March 27, 2020

**RE: Branding Iron at Sterling Ranch Filing No.2
Response to Comment Letter.**

### SAND CREEK BANK STABILIZATION PLAN

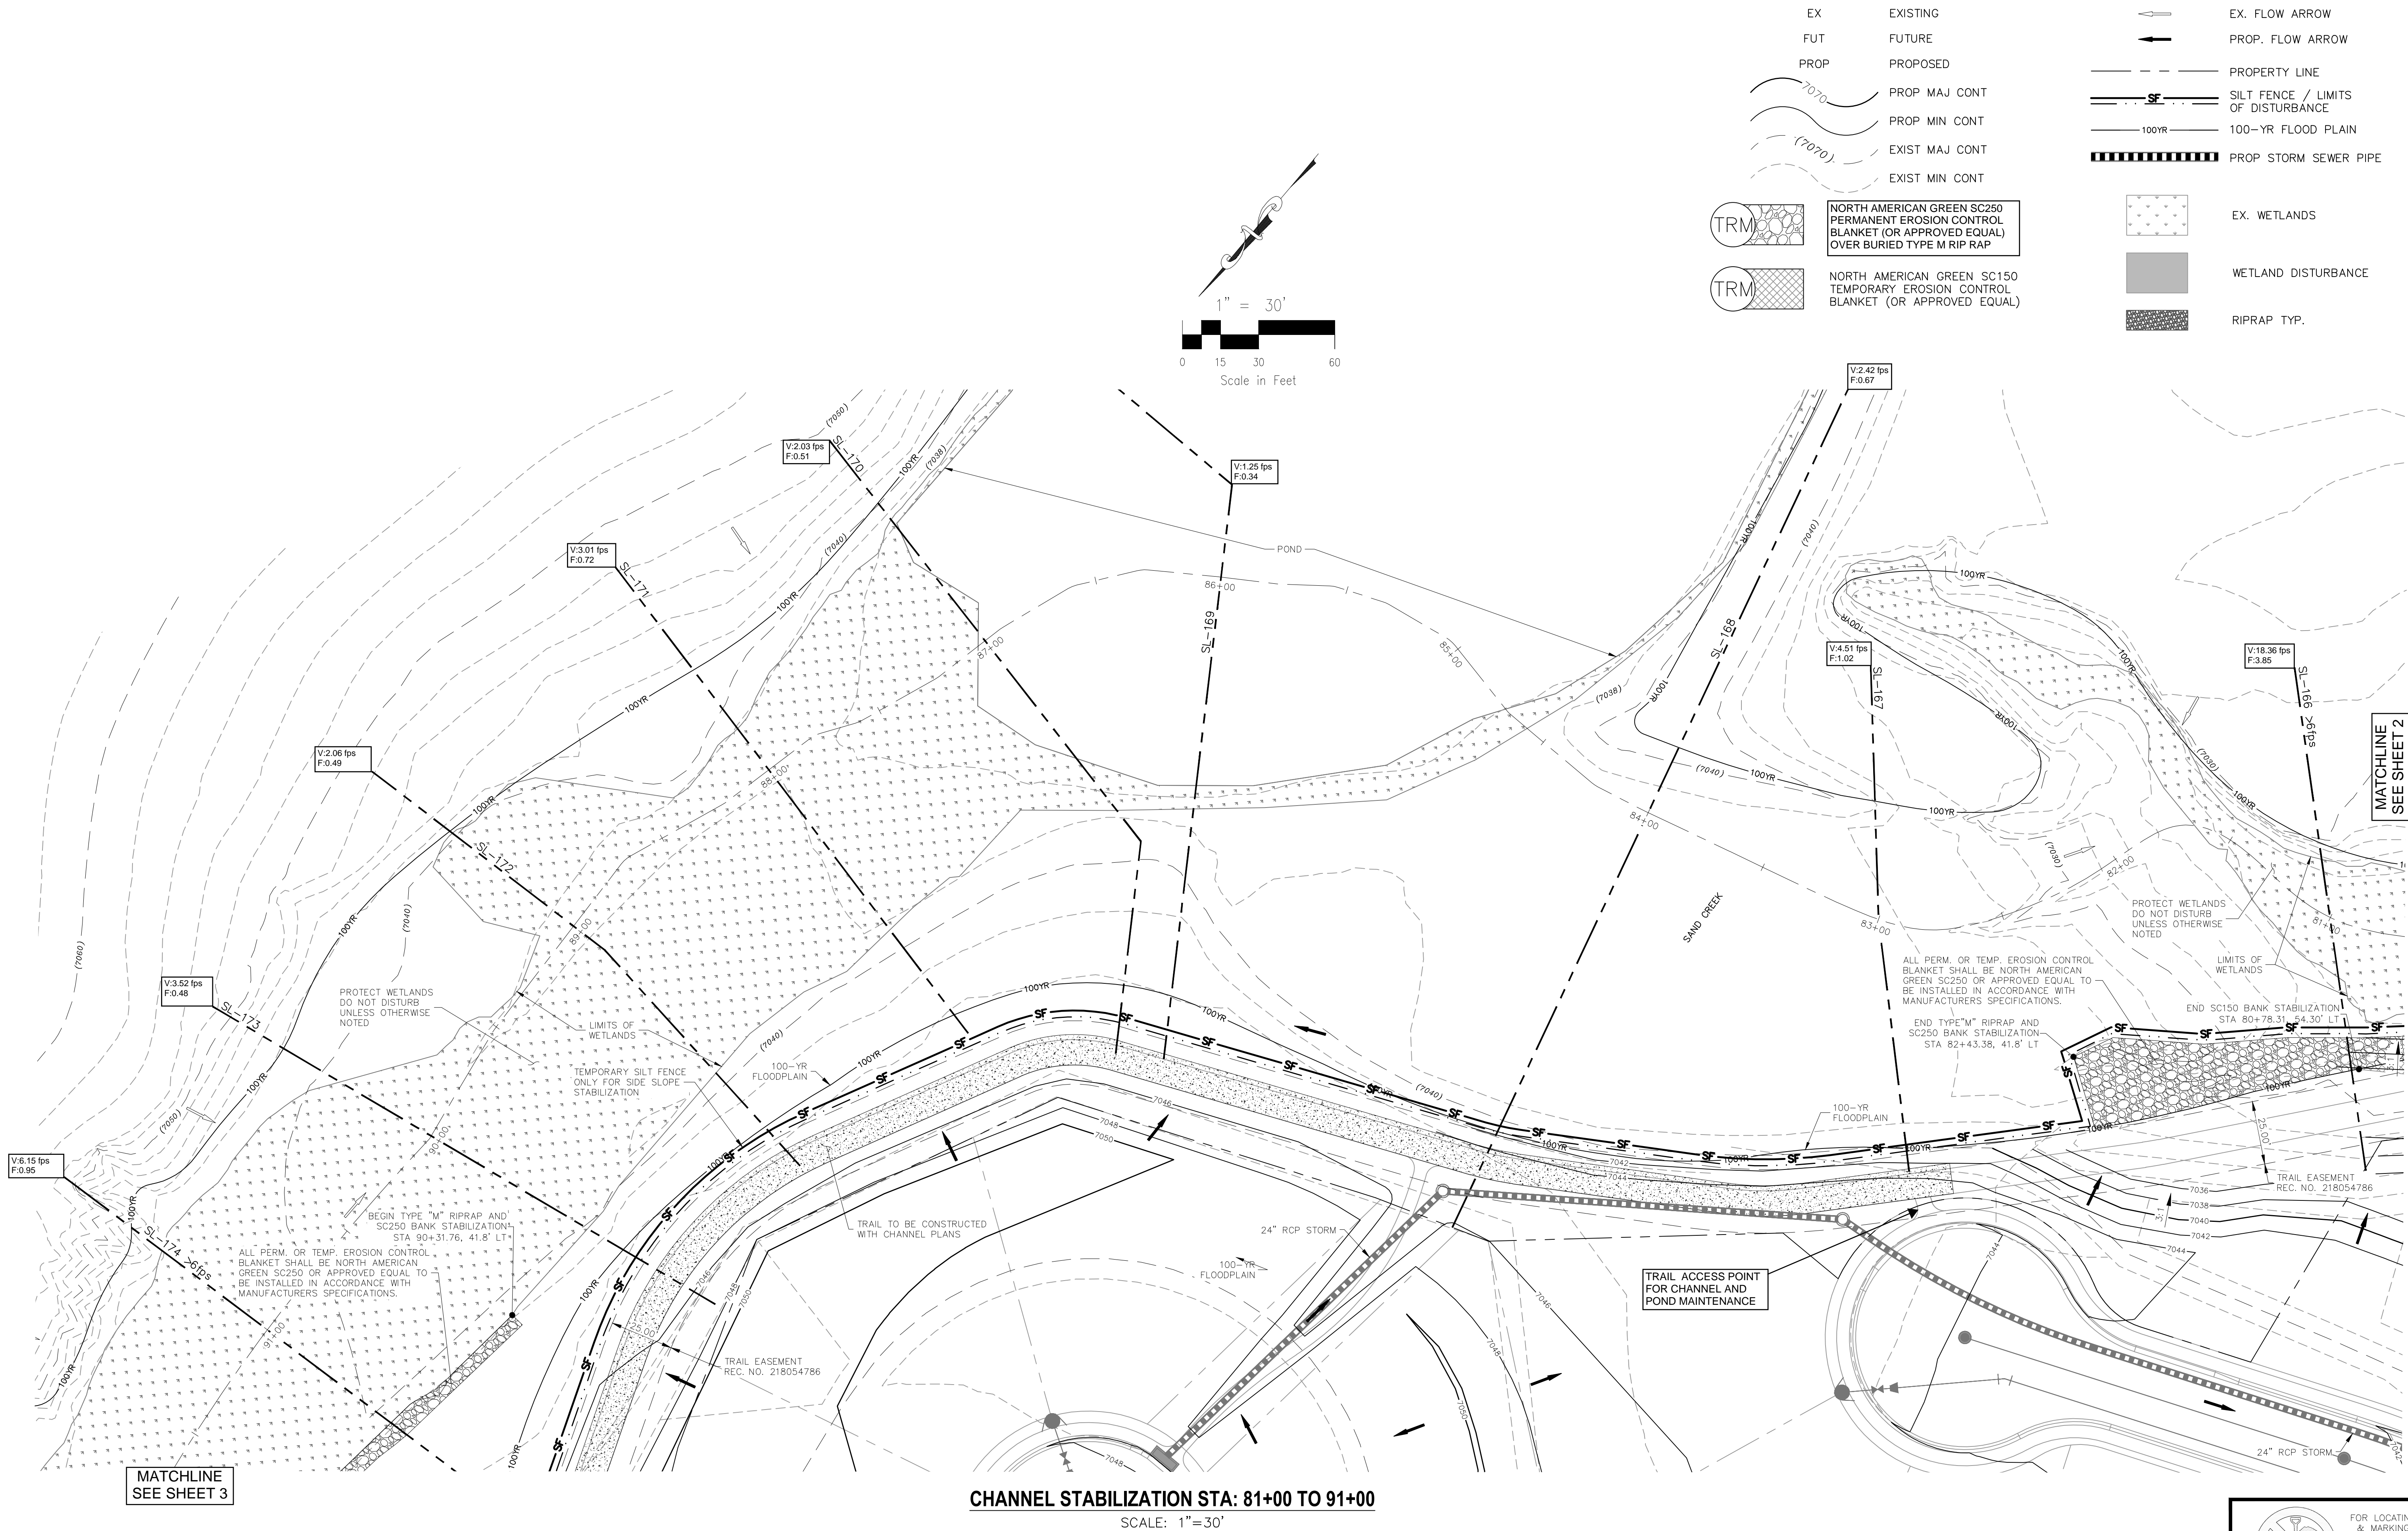
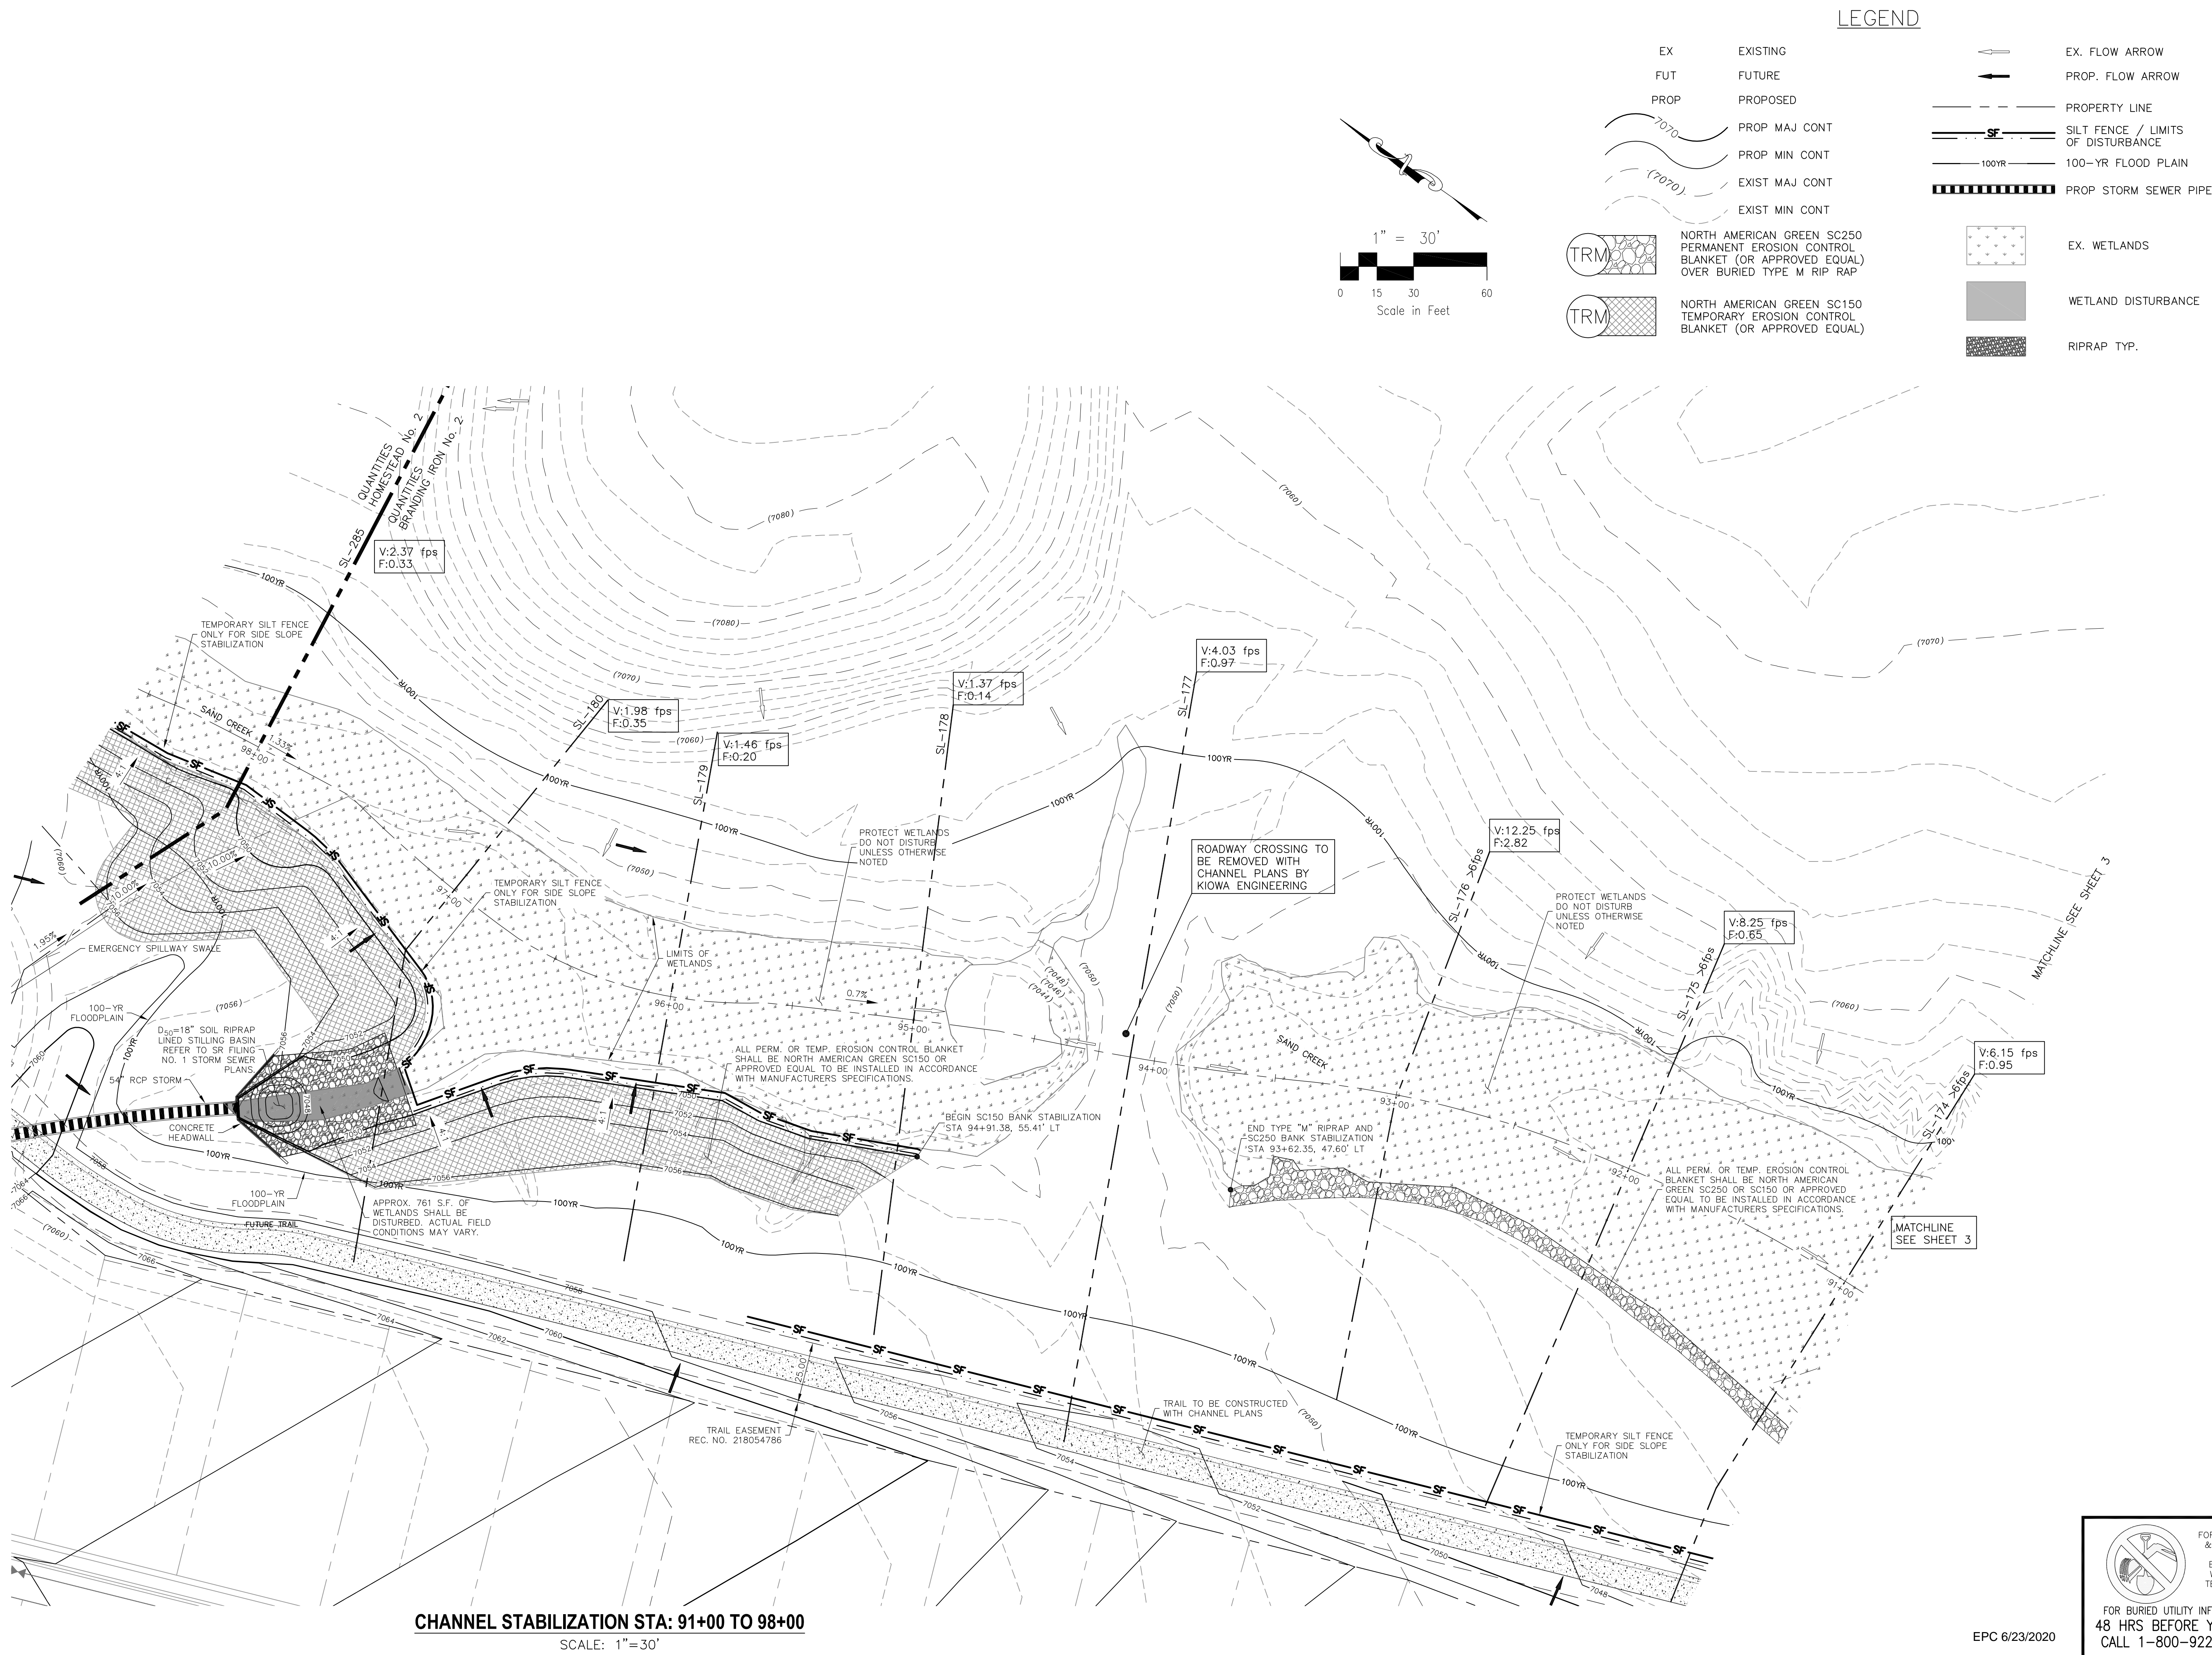
1. Sand Creek channel construction plans:
 - a. Provide a complete channel plan and profile for the applicable reaches.
 - b. The channel design needs to be verified for overall stability including velocities and shear stresses with the proposed blanketing (ECB / TRM).
 - c. **See redlines on bank stabilization plans.**
Updated redlines addressed
2. **Resolved.**
3. Storm Drain Plans
 - a. Label all storm drain segments as public or private/district. **Unresolved.**
 - b. **Resolved.**
4. If there will be USPS mail kiosk/cluster(s) in this subdivision provide location(s) and details. **Not found.**
Coordination with USPS in ongoing process.
5. **Resolved.**
6. **Provide pedestrian ramps for the three intersections along Yellowtail Way.**
Let's discuss.

YELLOWTAIL WAY SANITARY SEWER STA 1+00.00 TO STA 8+57.05

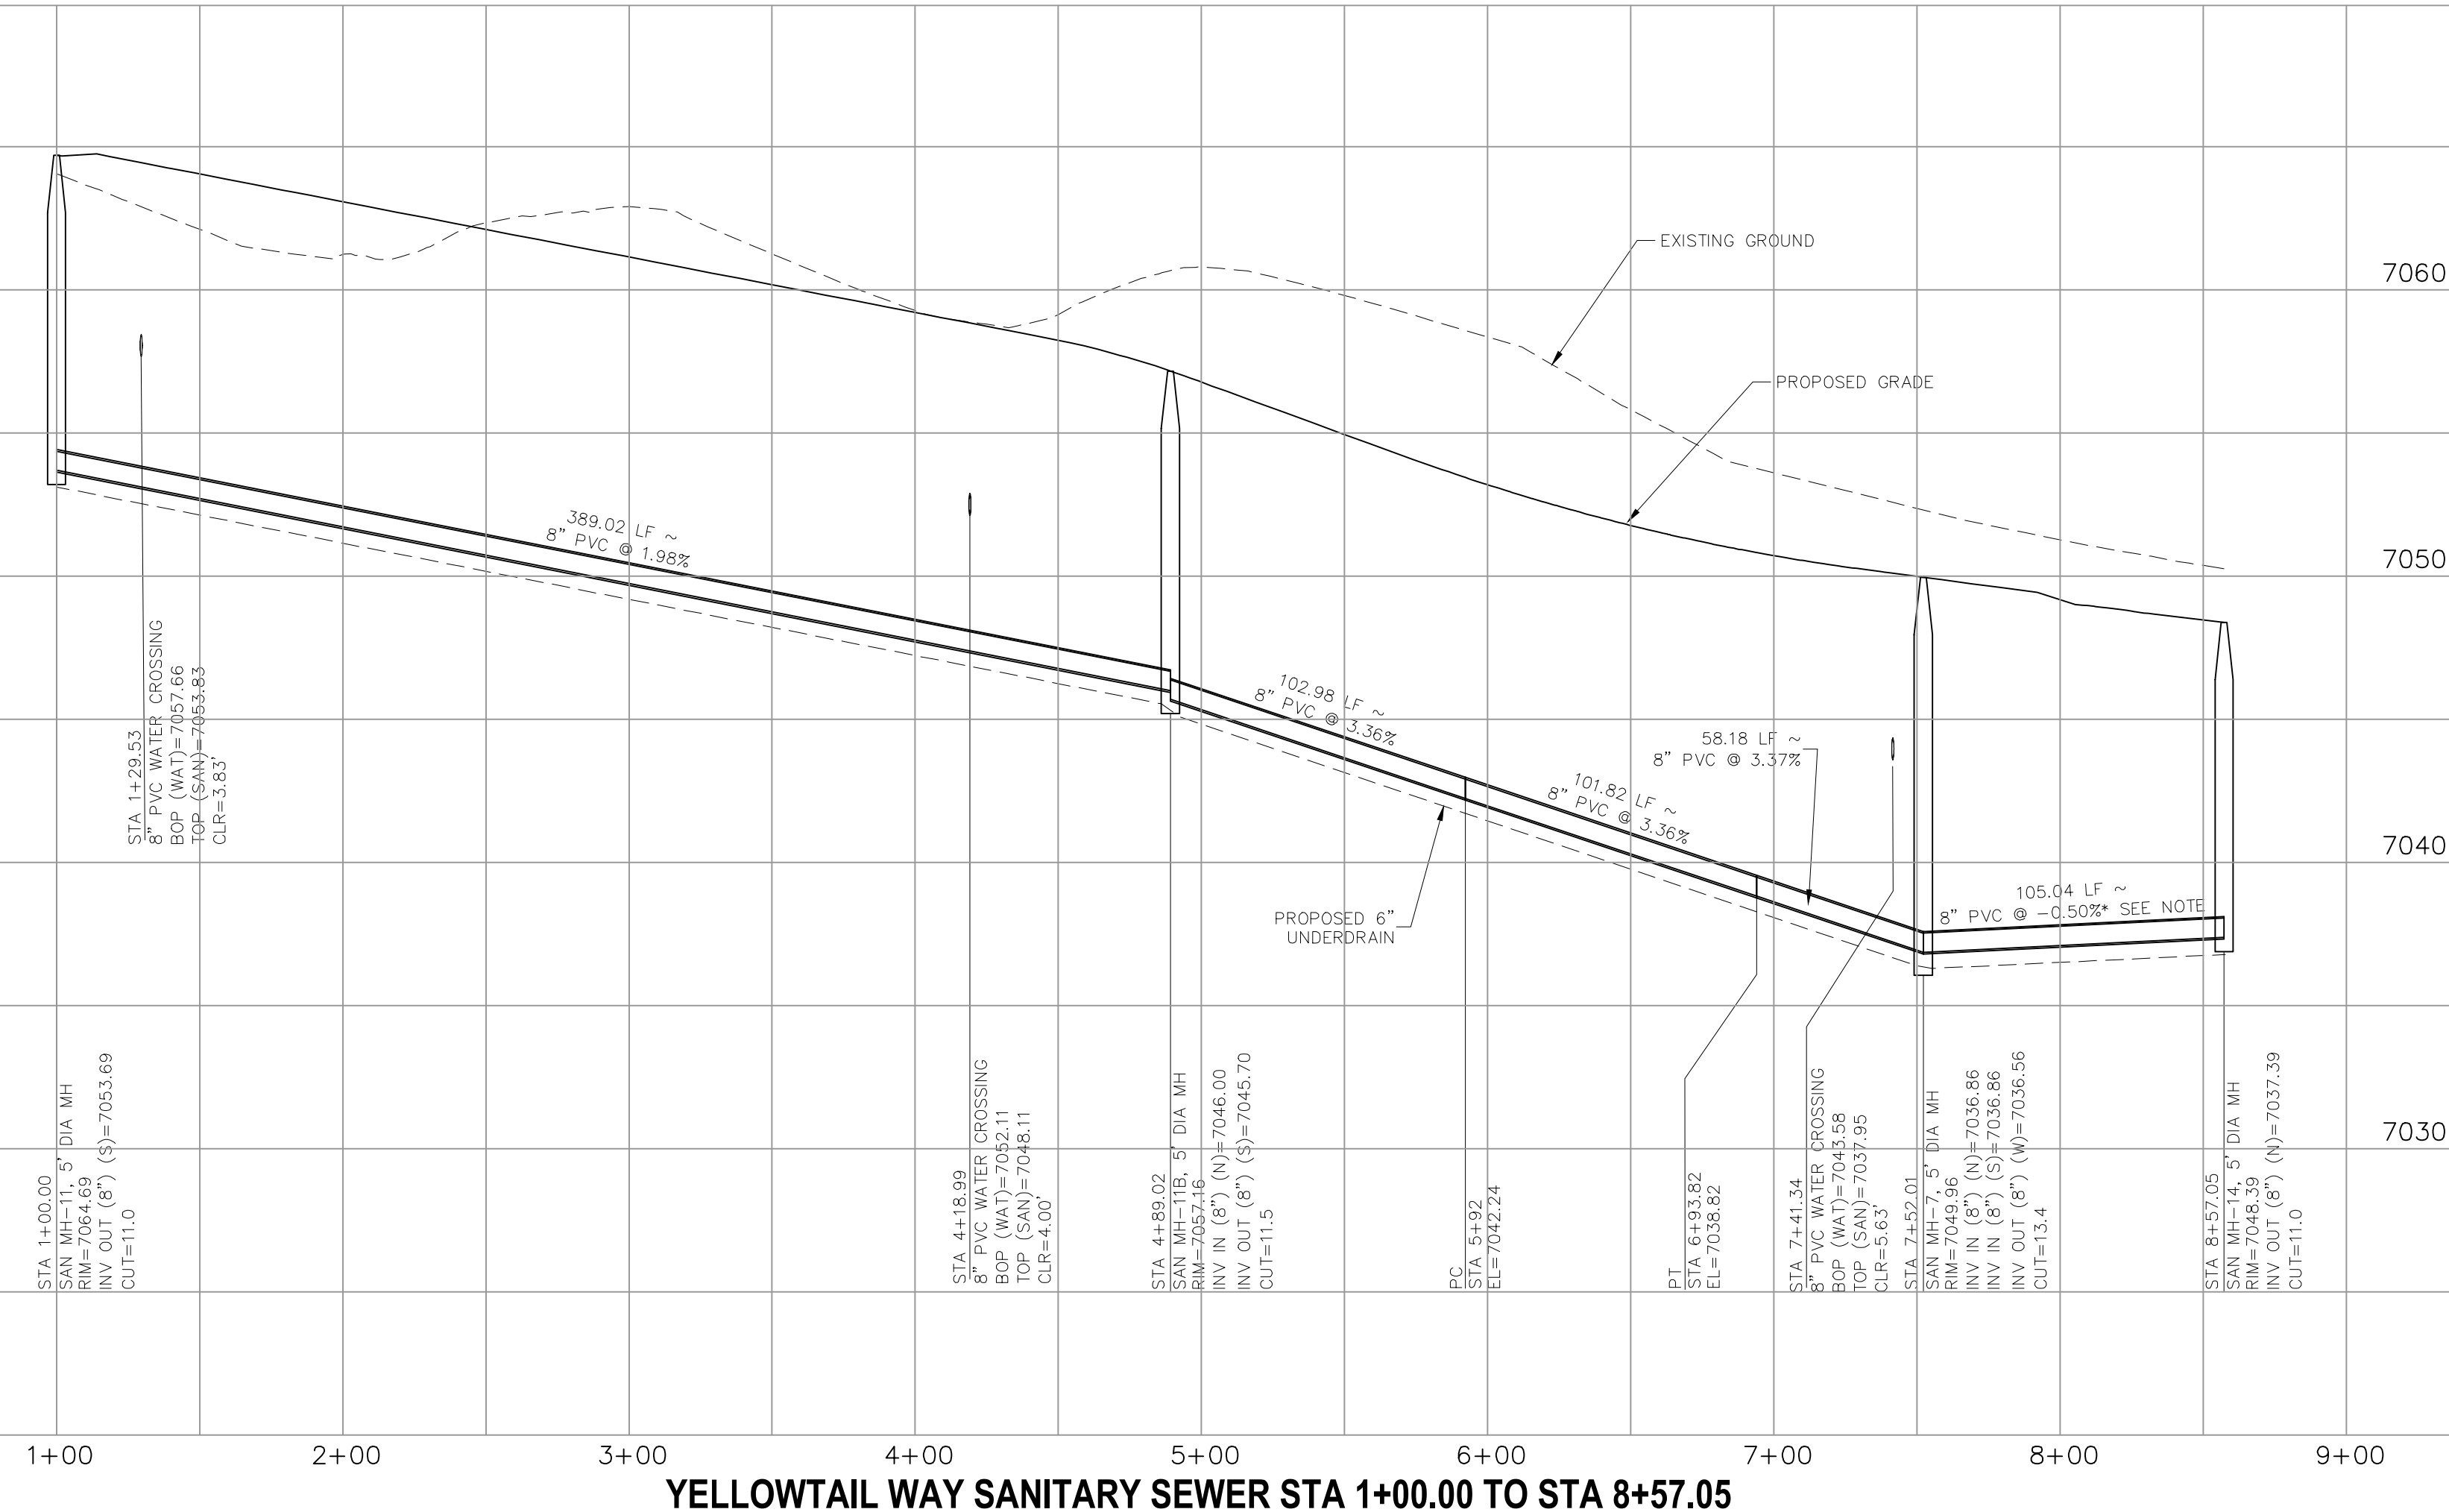
Add pedestrian ramps for Yellowtail Way crossings also.

Let's discuss.
